From: Sue Howell
Sent: 30 April 2014 16:04
To: Planning.Responses
Cc: Cian Cronin
Subject: RE: Planning Consultation on: Y/23/14/RES

Comments from Greenspace

APPLICATION **Y/23/14/RES**
NO:
Registered: 27th March
 2014
Site Address: Land South of Fellows Gardens Yapton BN18
 0HW
Grid Reference: 498298 102957
Description of Works: Approval of Reserved Matters: Appearance, Landscaping, Layout and Scale following Outline Planning Permission Y/30/13 for 34No. dwellings, including 10No. affordable with access and ancillary works. Departure from the Development Plan.

PLANT SCHEDULE TO ID583.03

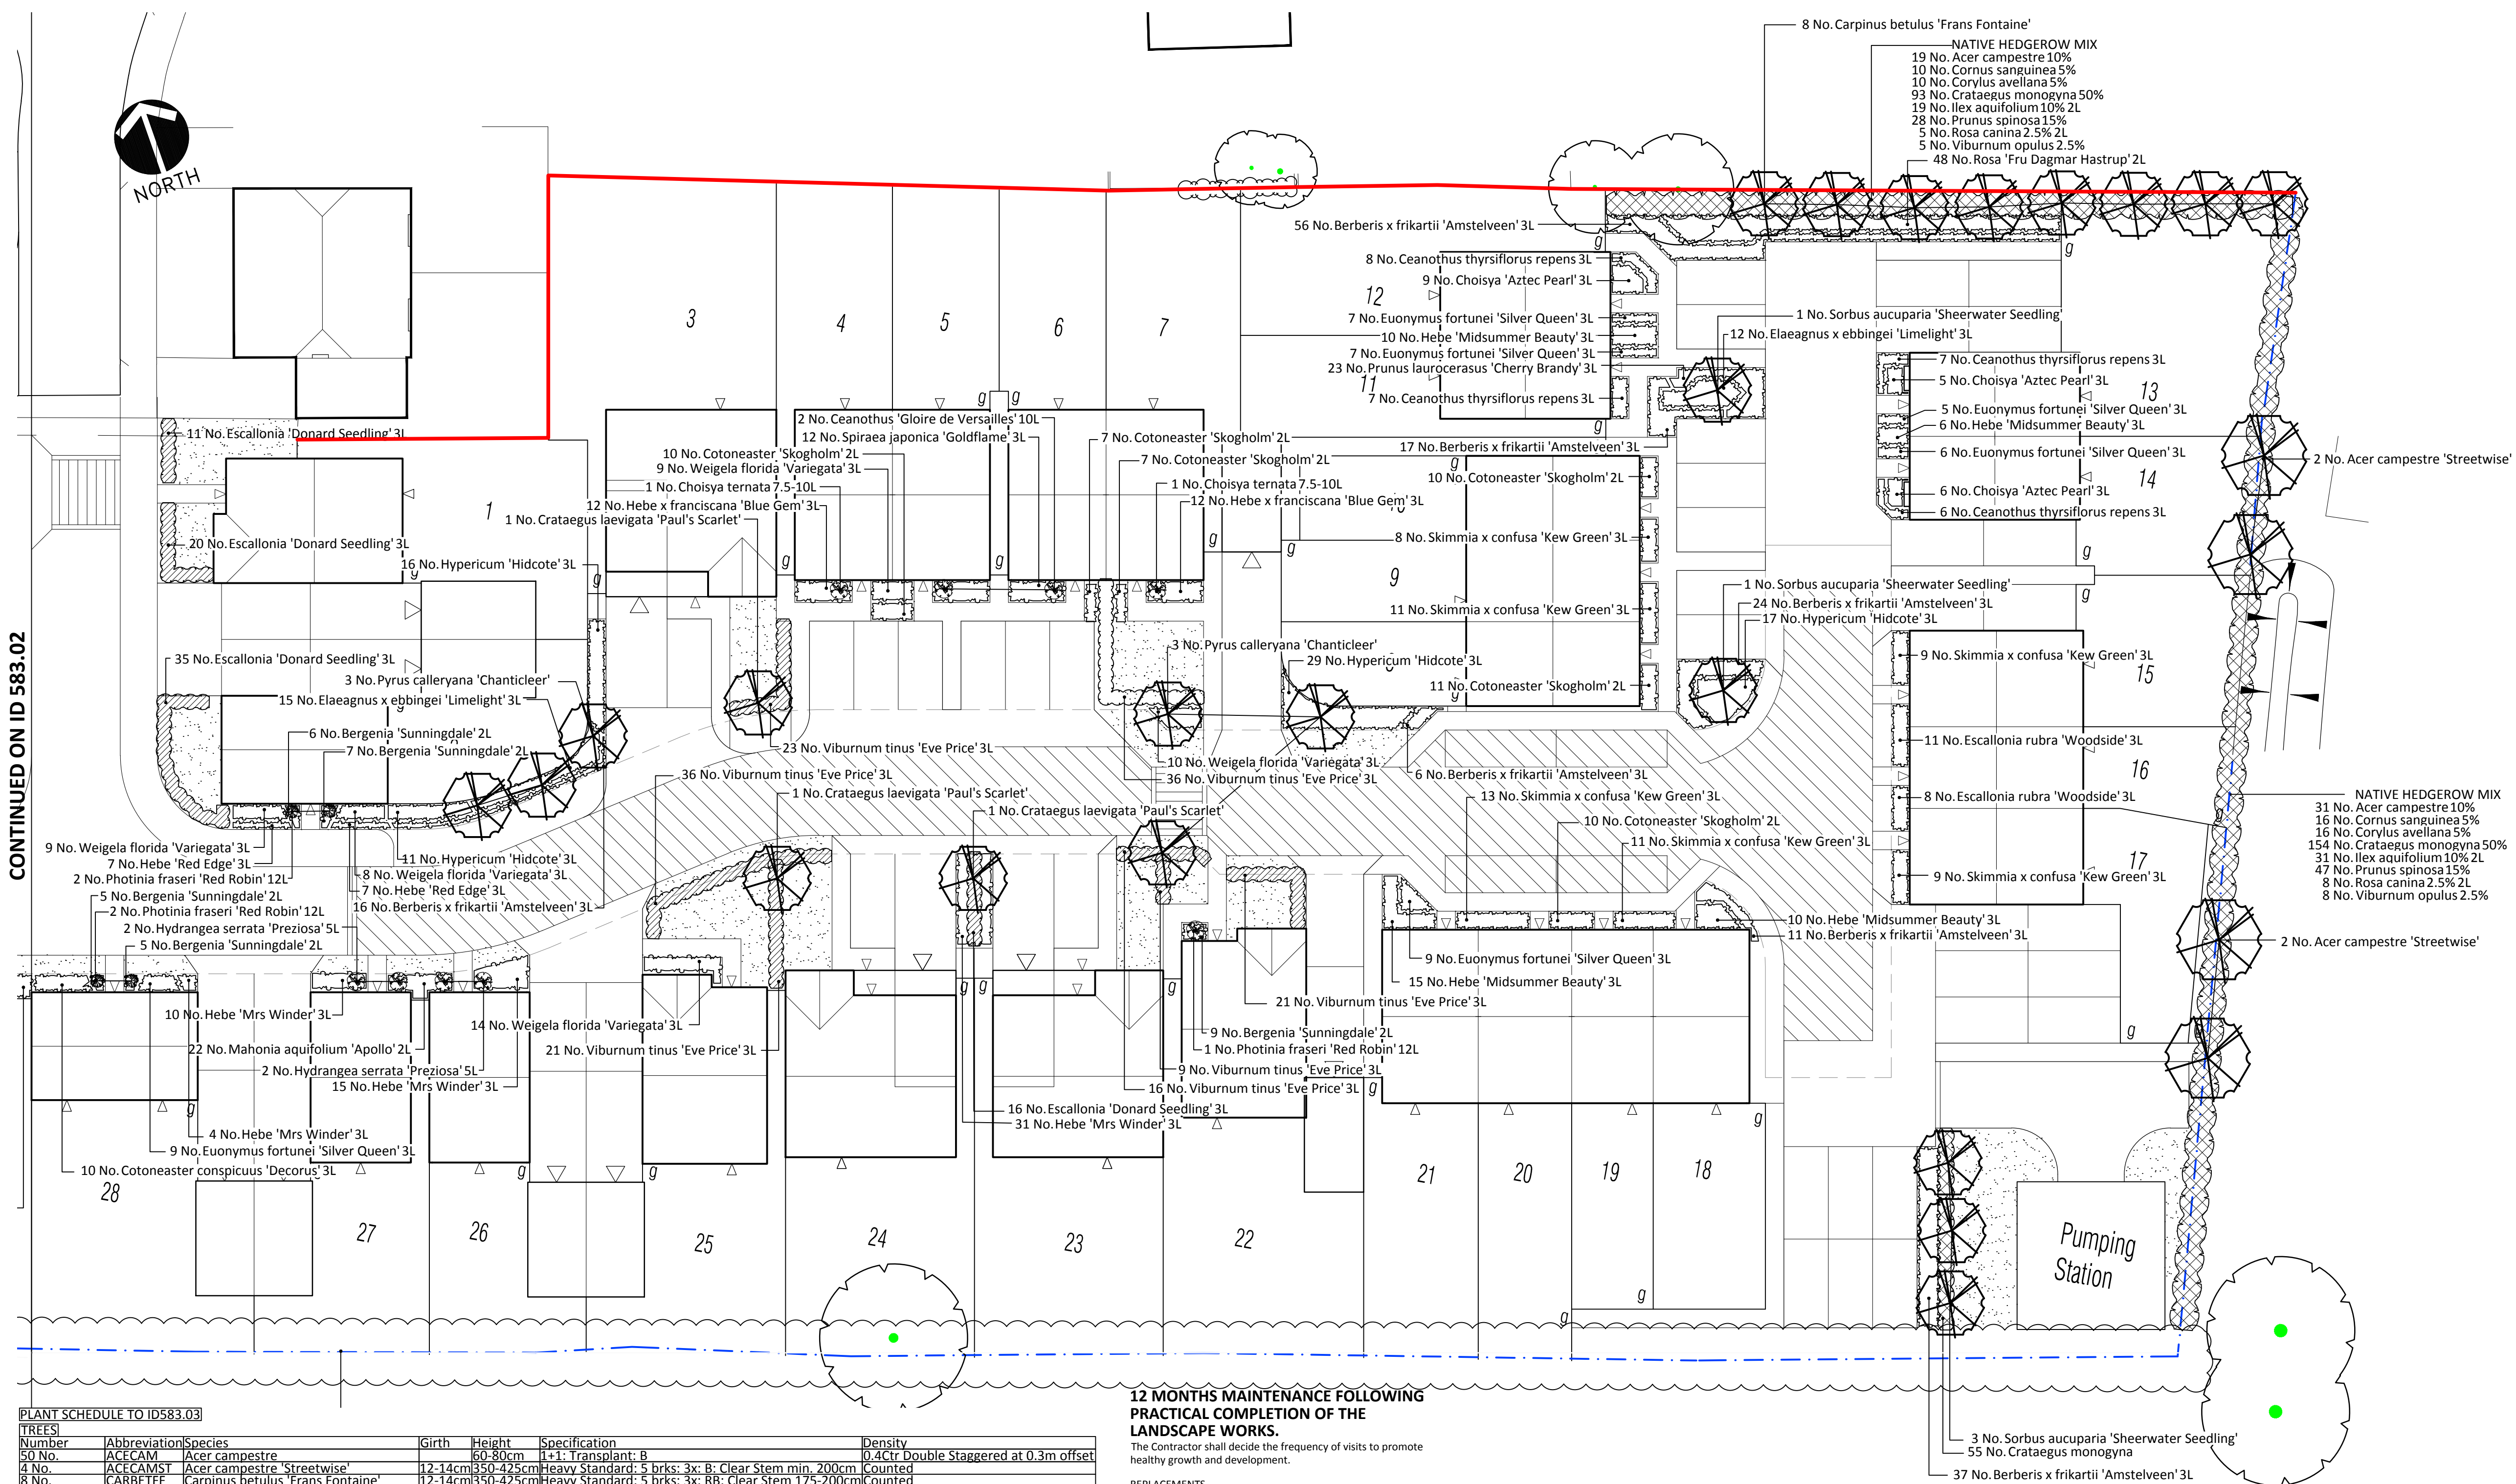
Appearance and landscaping – We would advise that the detail given in dwg ID583.02A and ID583.03A are appropriate for setting and do contain the detail required regarding species choice, densities and size at time of planting.

We note with caution the hedge to the southern boundary which the retention and improvement of, is paramount to the screening and the bio-diversity of this development. This hedgerow will need protection prior to and at time of construction along with any other existing trees to be retained from within and those bordering the site. This should be in accordance with BS 5837:2102 'Trees in relation to construction' The southern boundary hedge gapping up with 74no Crataegus monogyna transplants we suspect will be insufficient to achieve a dense and uniform hedge after laying as proposed. The suggested allowance and mix we would recommend be amended so as to allow sufficient to improve, enhance and promote the future of this hedgerow.
